RE: Design Comments Rec'd 17.11.2022

Many thanks for your time on the teams call (15.11.2022) and the resulting comments (17.11.2022). Both were/are extremely useful in defining the Design officers' comments and highlighting areas where further explanation is required.

Proposed Elevations

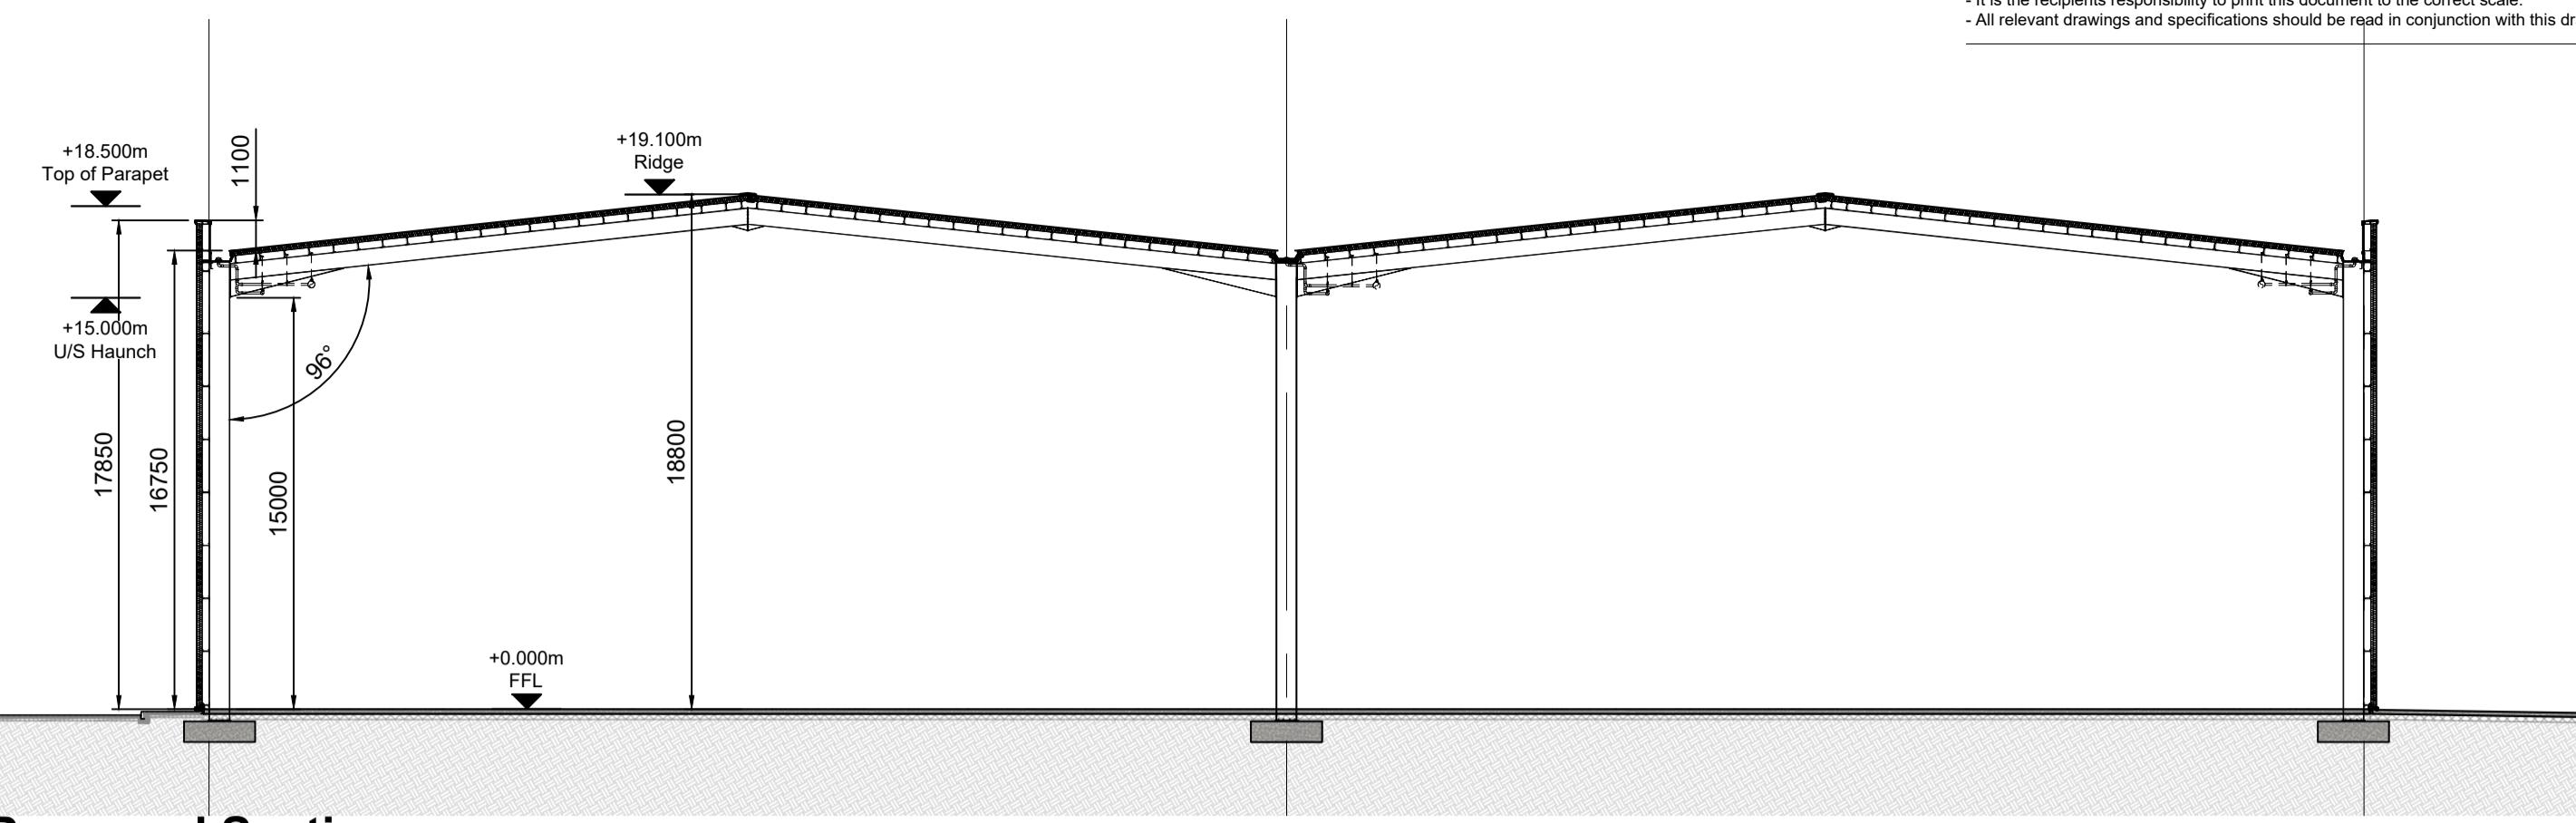
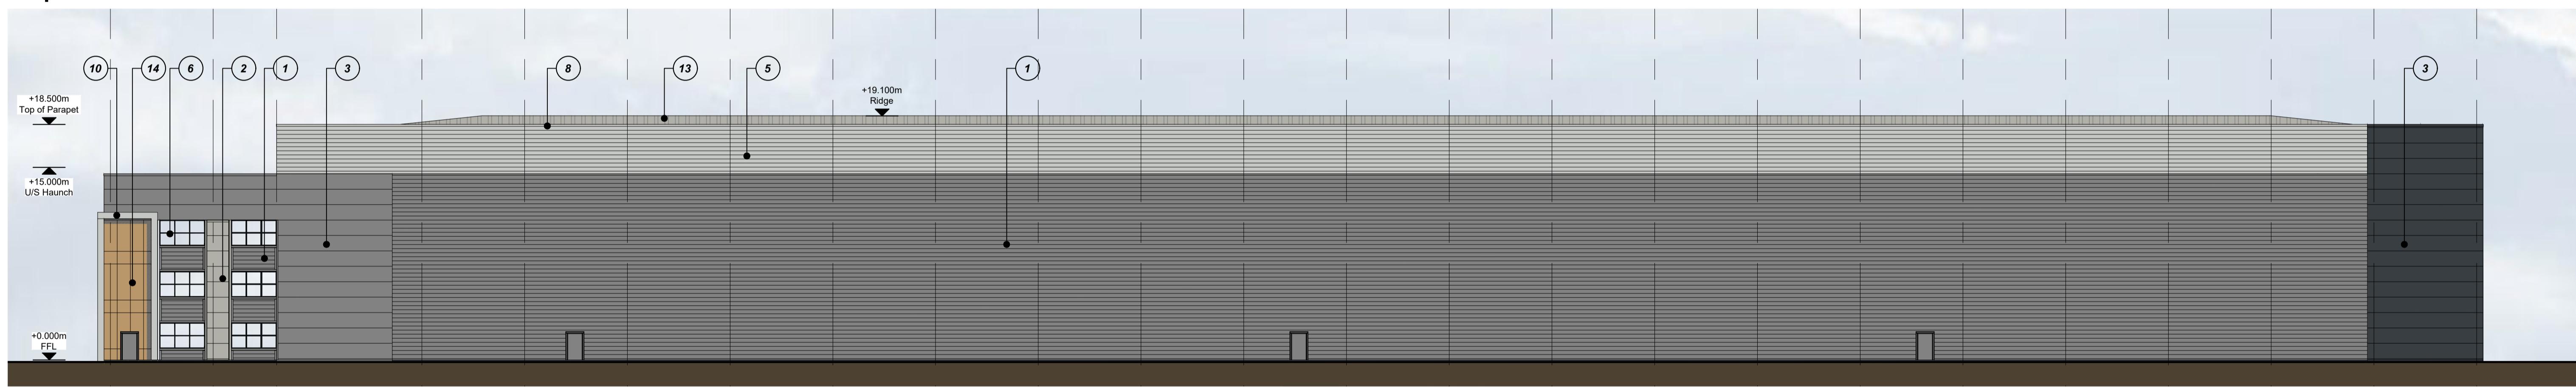
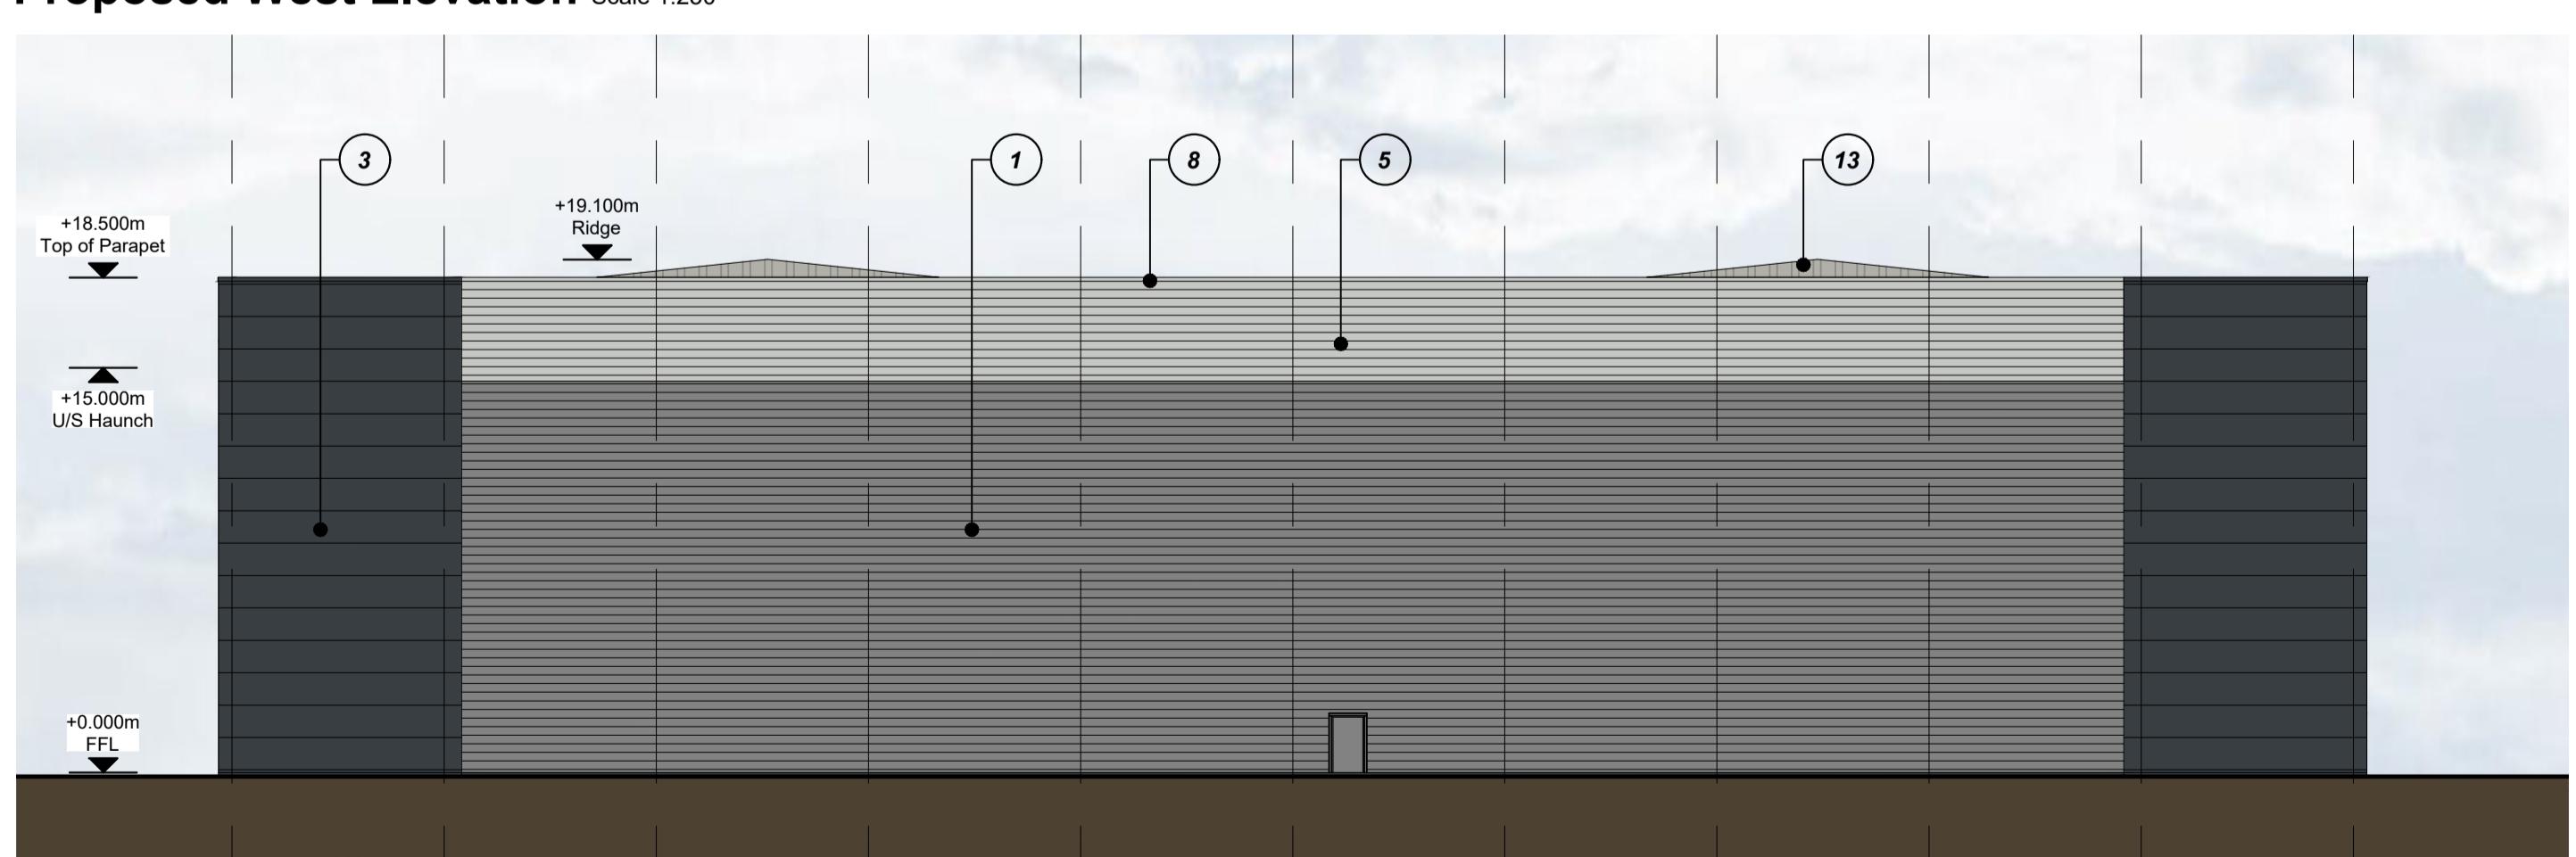
- **Develop a quality design strategy to break down mass of tall building (roofscape and facade)**

- **Review the architectural palette (including texture, colour, roofscape, signage opening and lighting)**

- Timber has been omitted. These areas now offer an opportunity for bronze features to break down the elevation and add excitement. This is in accordance with the hotel application adjacent.
- The texture of the cladding (profiles and orientation) and the depths of goalposts allied with the building form offers a considered, high quality principal elevation.
- Transparent elements offer a depth to the form while giving a glimpse of the structural frame within thus activating the elevation.
- The orientation and form of the roof is suitable for a building of this scale. Reorientation would vastly reduce the efficiency of the frame resulting in material wastage at odds with the design aspirations. Roof lights and or solar panels will both operate efficiently given the low pitch.

1. The office elevation has been amended to offer further articulation of the goalpost. The additional horizontal return takes precedent from the adjacent built and permitted context.
2. The architecture where the office meets the warehouse element has been simplified ensuring each element is read independently and cohesively.
3. The warehouse now features a 'lightbox' to the north eastern corner. This gives depth to the building while tying the warehouse and office elements together when viewed from the north.
4. The materials, form and design aesthetic have been amended to suit the comments received during the call in the 15th.
